Supporting Statement for Section 73 Application

Application Type: Variation of Condition (Approved Plans)

Site: The Bridge Hotel, 4 Bridge Road, Sutton Bridge, Spalding, PE12 9UA

Proposal: Amendments to the approved drawings to reflect design and technical adjustments during detailed design and construction stage.

|                                                                                       | Detailed Elevations                                    | As shown @ A1<br>Do not scale<br>from drawings |

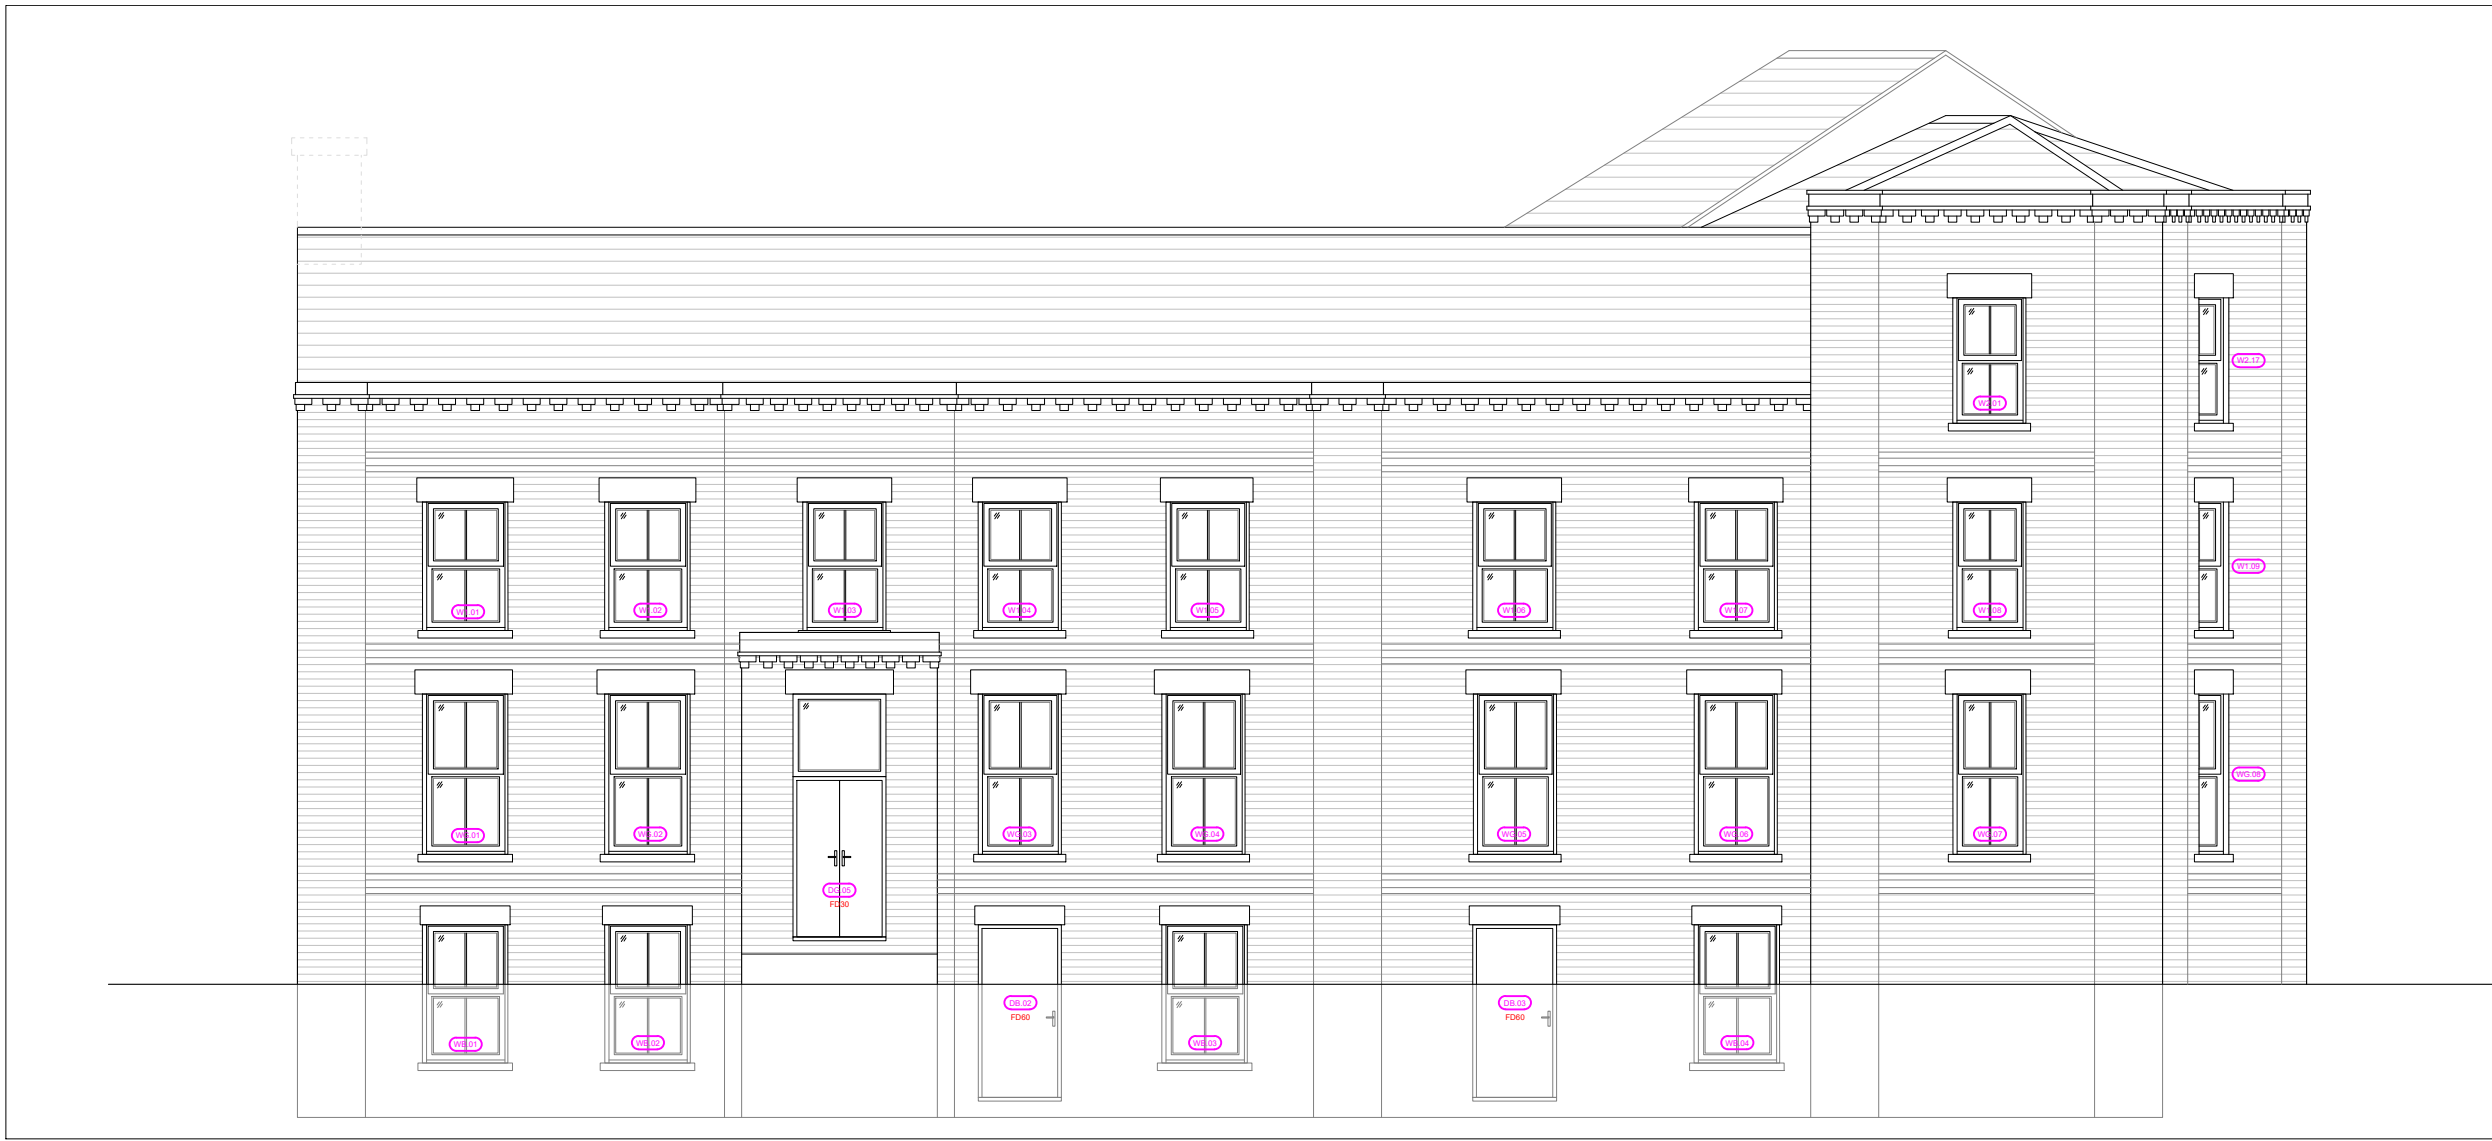
- **Rear Elevation:**
Removal of the step feature within the rear elevation while retaining the twin gables, to simplify construction and maintain cost efficiency.

- **Windows:**
Minor adjustments to sill and head heights to comply with Condition 4 regarding the Finished Floor Level (FFL) set for flood mitigation and to reflect engineers' specifications for floor structures, ensuring no structural conflicts.

- **Internal Layout & Attic Use:**
Redesign of Unit 15 within the attic to occupy the full attic space due to head height constraints identified during technical design. Two new windows are proposed on the rear elevation and one on the side elevation at second-floor level to serve this space. Unit 15 has previously been proposed as a 1 bedroom unit, as part of this application it would become a 3 bedroom unit.

- **Roof Alterations:**
Introduction of two conservation-style rooflights (rear and side-facing slopes) to provide natural light to habitable areas, and raising of the flat roof portion between the rear gables to achieve sufficient head height on the landing and stairwell. An Automatic Opening Vent (AOV) has also been positioned on the rear roof slope to meet fire safety requirements as per the Fire Engineer's advice.
